**KIRKLEES METROPOLITAN COUNCIL
INVESTMENT & REGENERATION SERVICE**

DELEGATED DECISION TO DETERMINE PLANNING APPLICATIONS

Reference No: 2021/62/91792/E

Description: Erection of extension and alterations to outbuilding to
create dwelling forming annex accommodation
associated with Lower Sowood Farm, Healey Lane,
Bristfield, Dewsbury, WF12 0NT

PROJECT/ Refurbishment of existing outbuilding.
ADDRESS / Lower Sowood Farm, Healey Lane, Bristfield, Wakefield WF12 0NT
POSTCODE / GAG 266
JOB No. / **ELEVATIONS**
DWG TITLE / 3000 REV -
DWG No. / JF
DRAWN BY / SG
CHECKED BY / 28.04.2021
DATE / 1:100
SCALE / A3
PAPER SIZE / PROPOSED
STATUS /

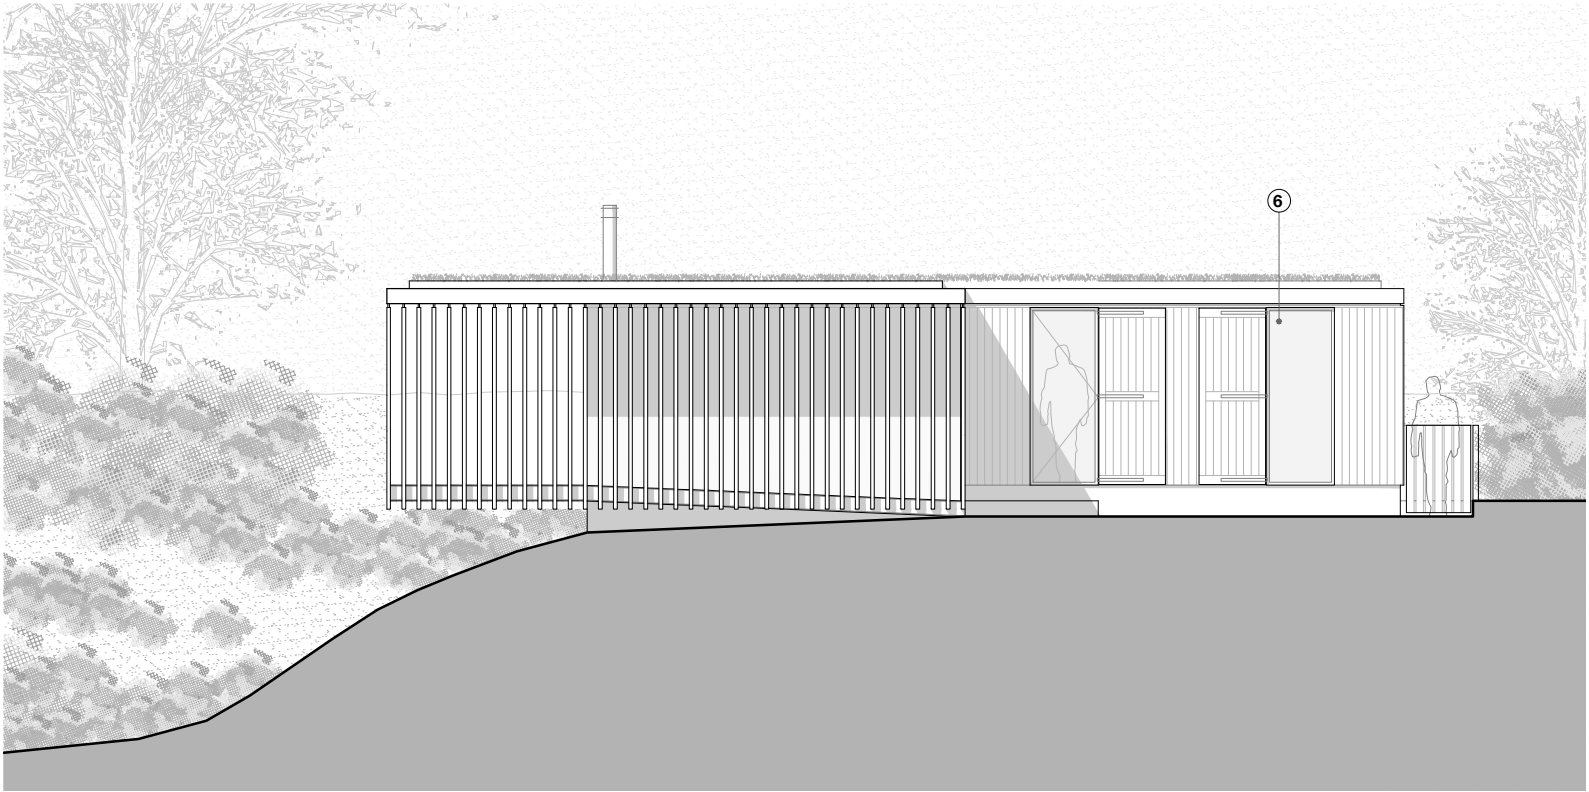
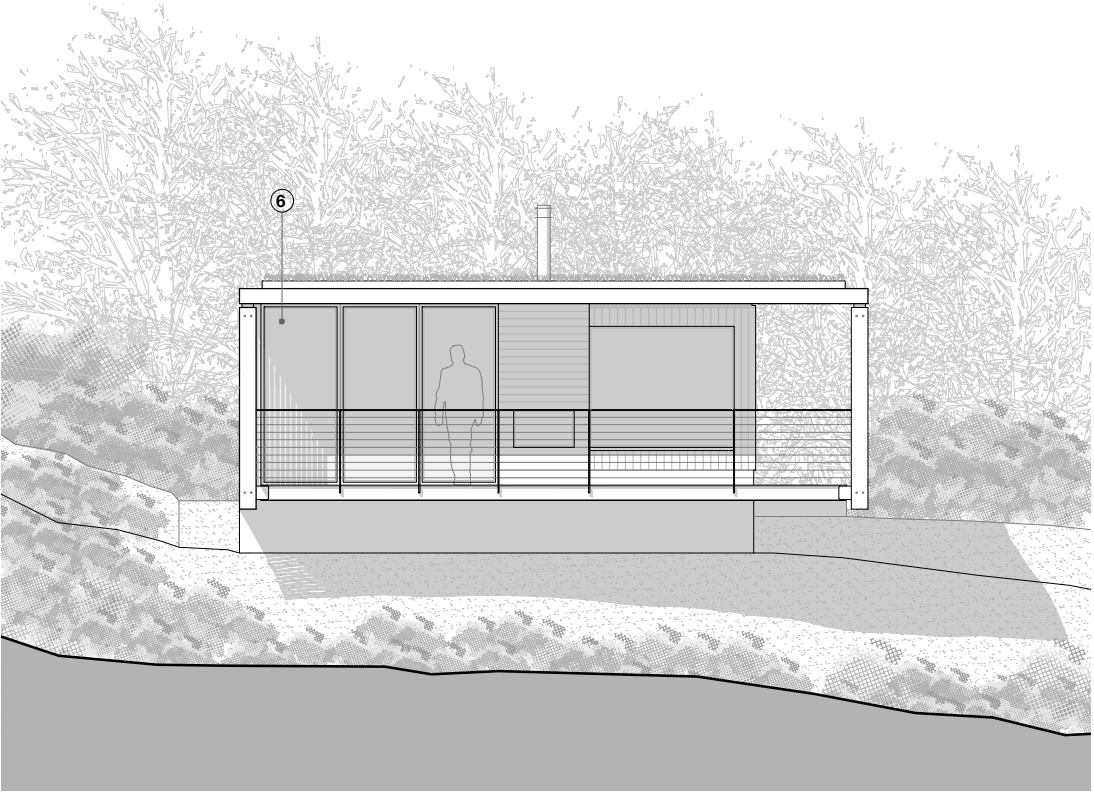
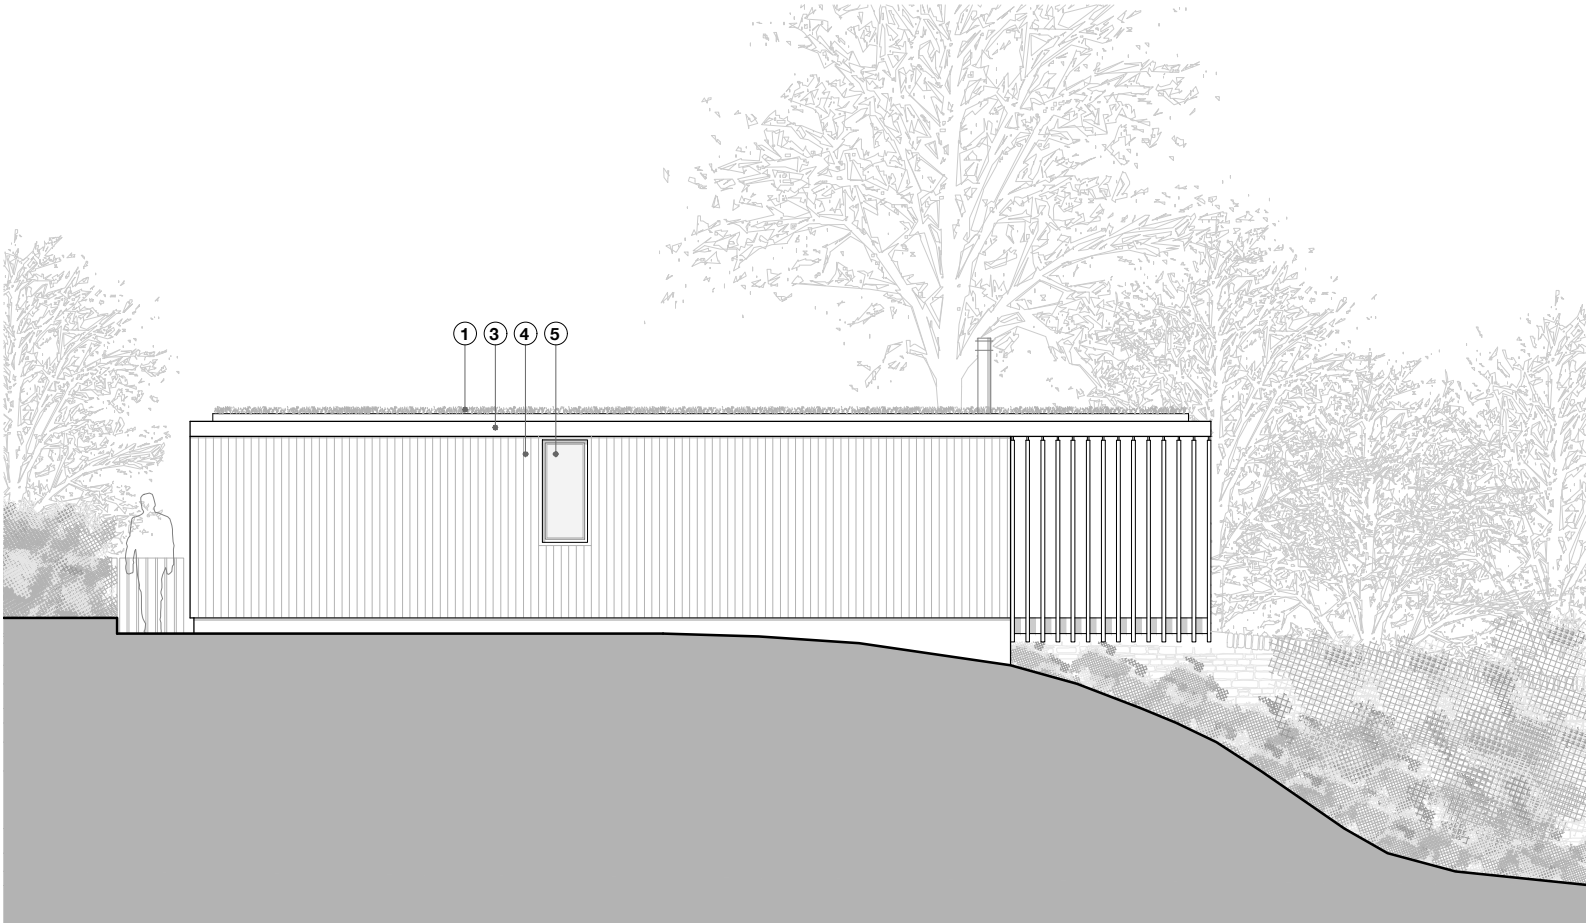
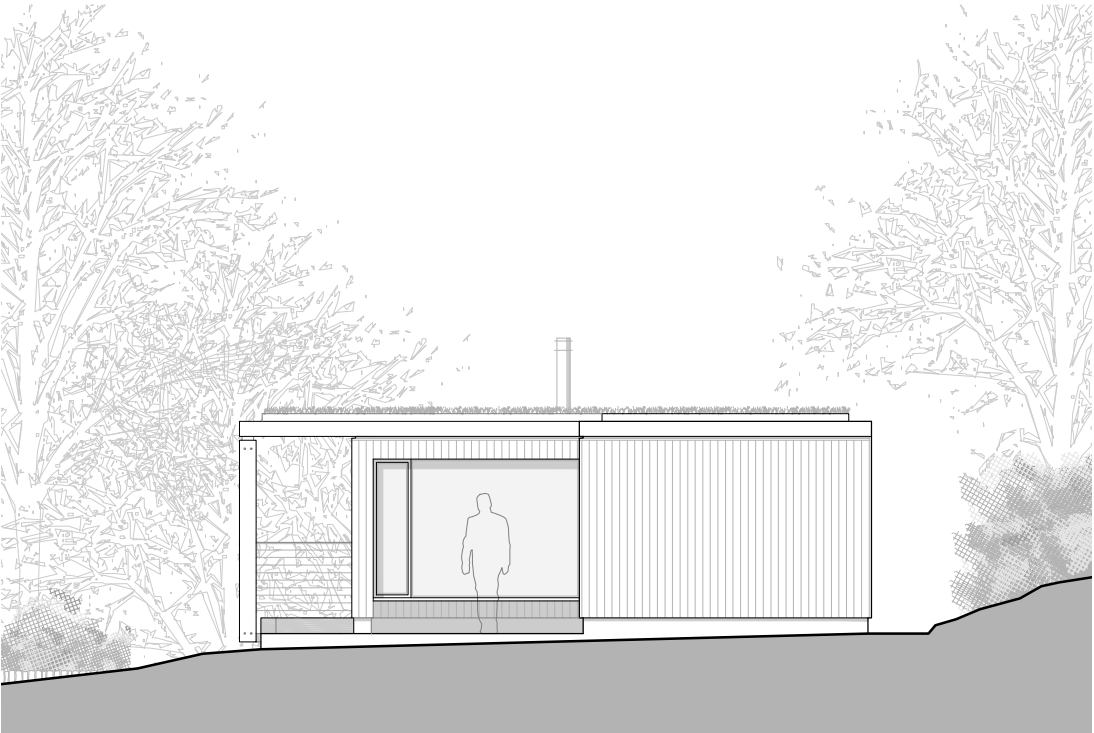
Firstly, whilst the height would be acceptable in assessing the spatial increase, the volume indicates a clear spatial increase in volume, affecting the spatial aspect of the openness of the Green Belt negatively. The increases in massing, overall raising of the roof profile and domestication of the building present a negative impact on the visual aspect of the Green Belt also.

In terms of subsection c, the spatial calculations above and the visual increase in bulk and massing would result in a disproportionate addition in the Green Belt. Were the building included in the site edged red of the nearby dwellinghouse, it could in principle be assessed as an extension to this building and would potentially comply with the policy. As the Location Plan site edged red includes this site only; it is not appropriate development the Green Belt when assessed on these terms. The site is not within the curtilage of the dwellinghouse known as Lower Sowood Farm, and it not considered to form part of the same planning unit. Policy LP57 on extensions and alterations in the Green Belt would therefore also not be complied with.

A further relevant exception can be found in NPPF paragraph 150, namely the re-use of buildings provided they are of permanent and substantial construction, provided they preserve the openness of the Green Belt. In this instance it has already been discussed how the increases in massing would negatively impact the spatial and visual aspects of the Green Belt. However, it is worth bearing in mind that not all of the building as it stands can be reasonably called permanent and substantial. The lean-to element at the northernmost part of the structure did not have permanent footings at the time of the case officer's visit, unlike the main timber element and the blockwork element. It therefore is a shed type lean-to structure, and further points to inappropriate development.

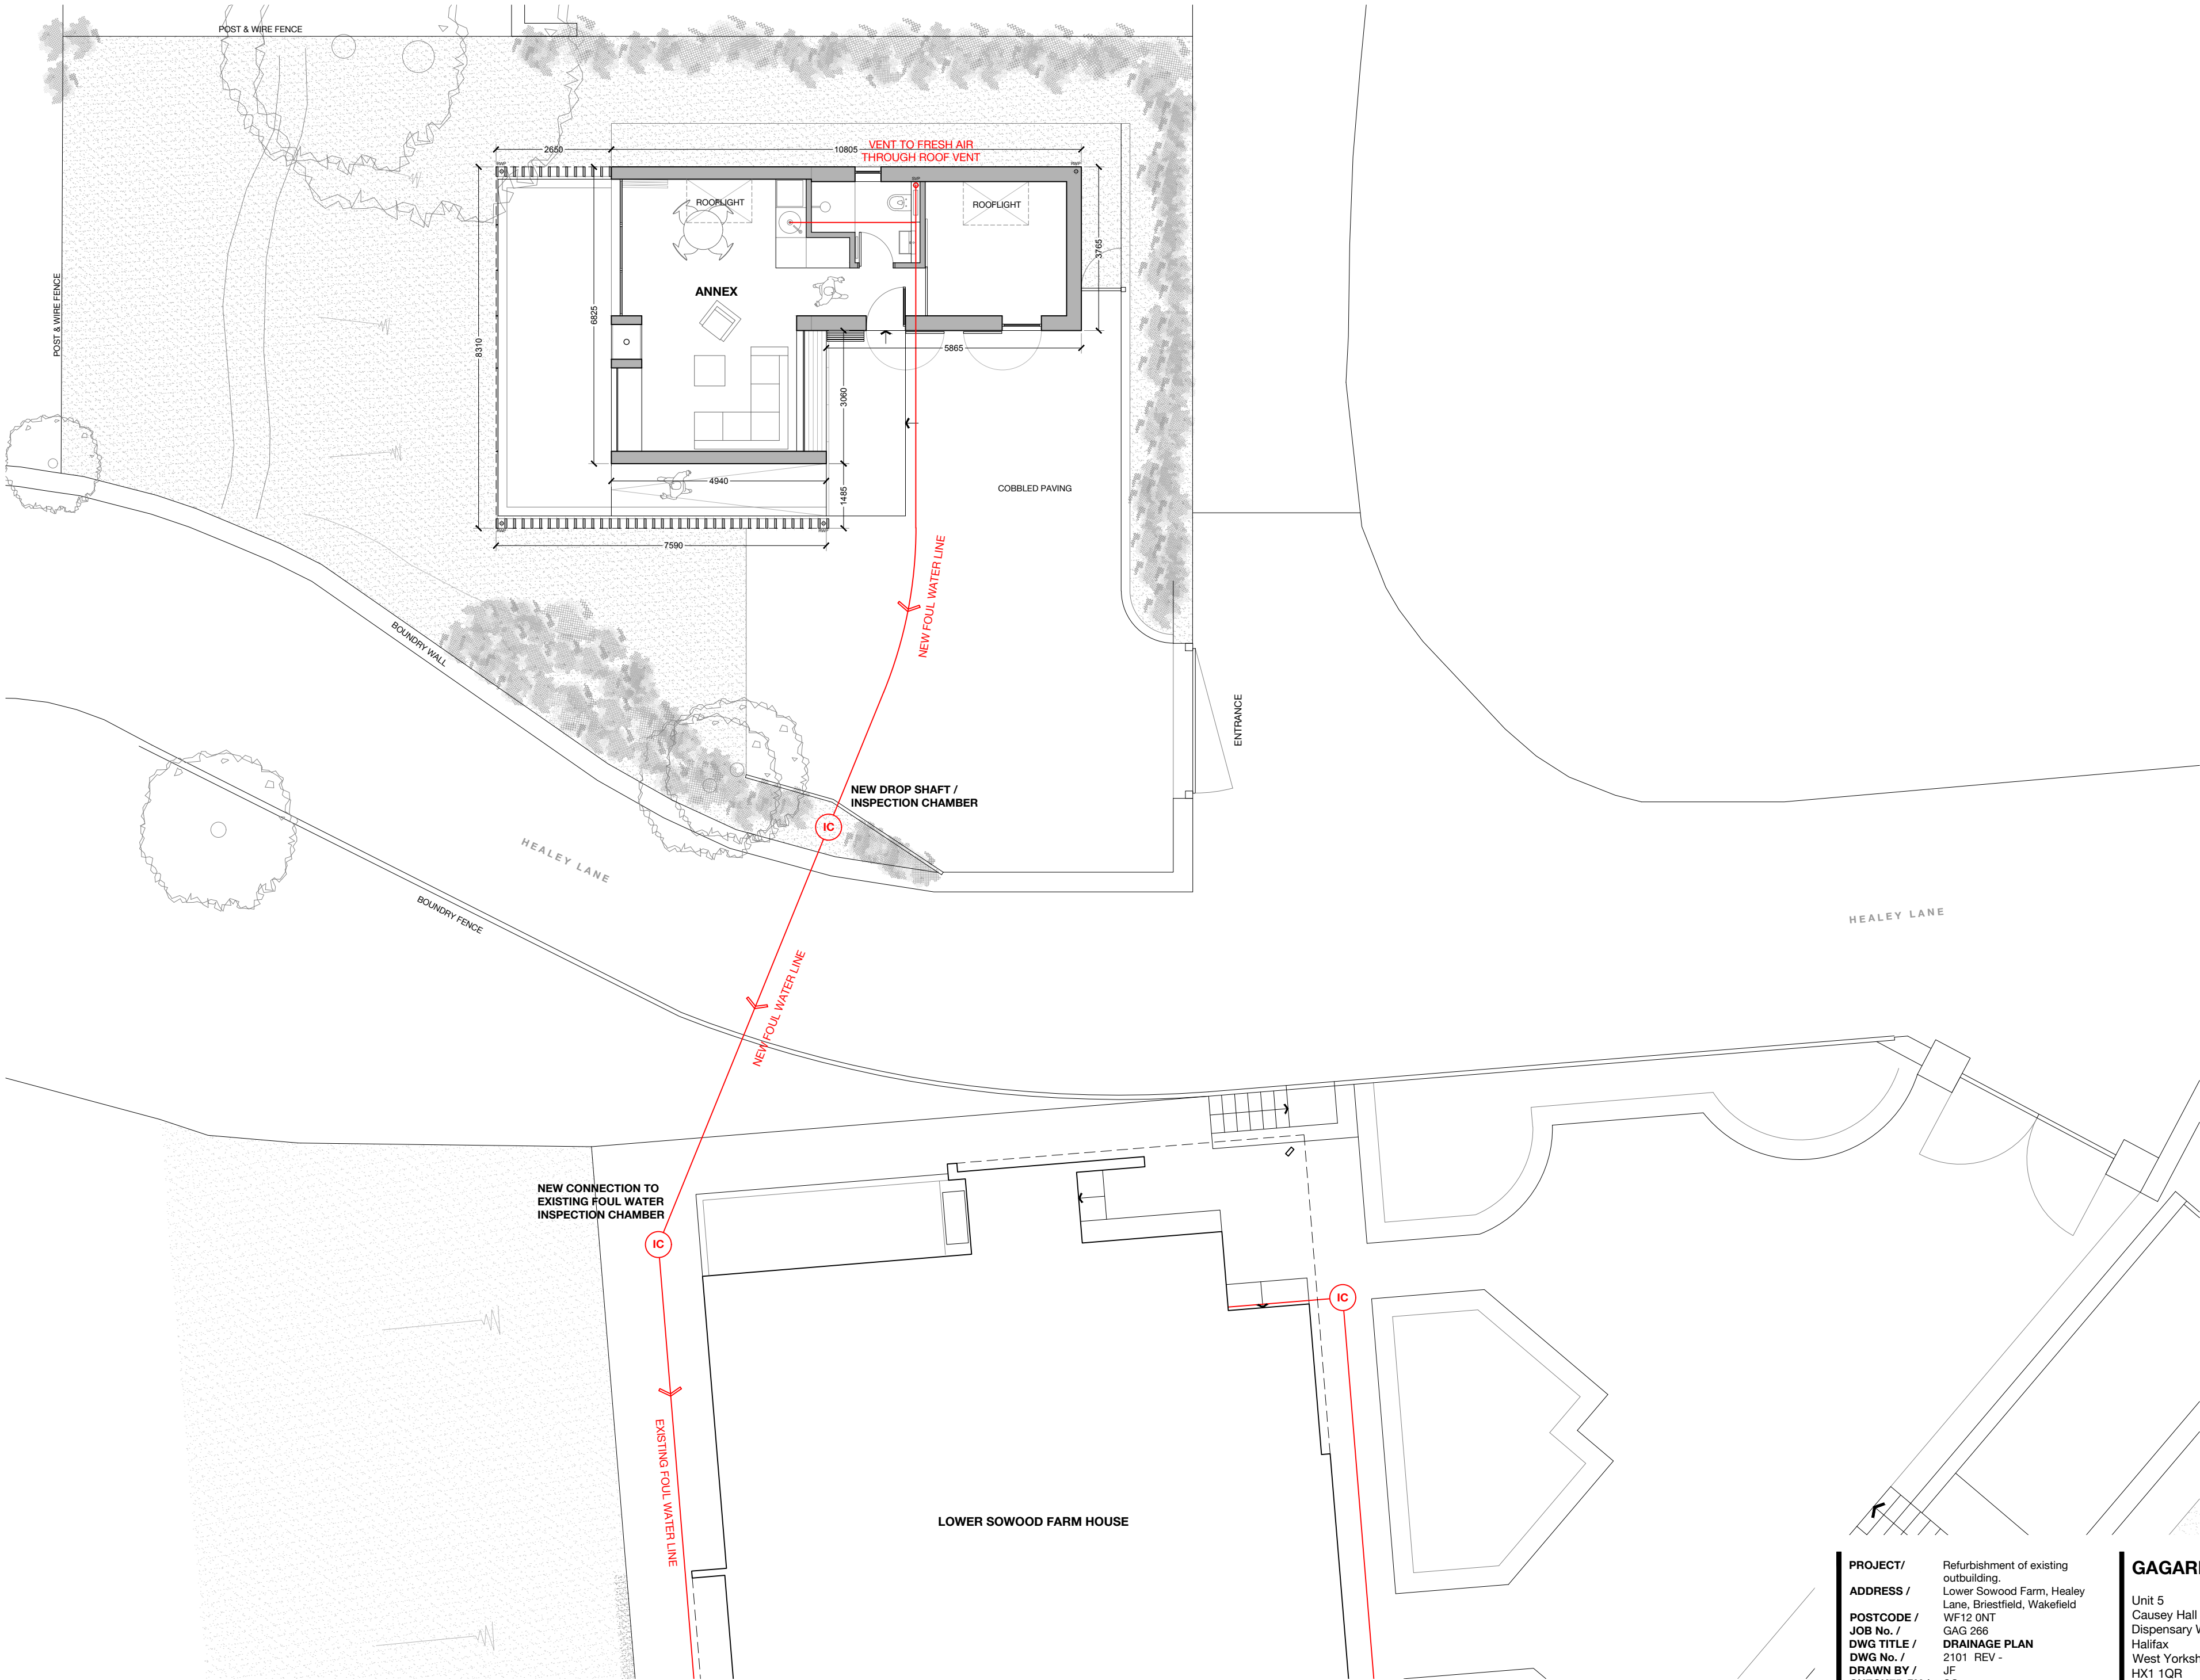
The applicant has indicated that a package treatment plant would be required to serve the development and would be connected to the existing foul drainage system that serves Lower Sowood House. Whilst this is acceptable in principle, further evidence would need to be provided to demonstrate that the existing system is of a sufficient size and capacity to serve the development.
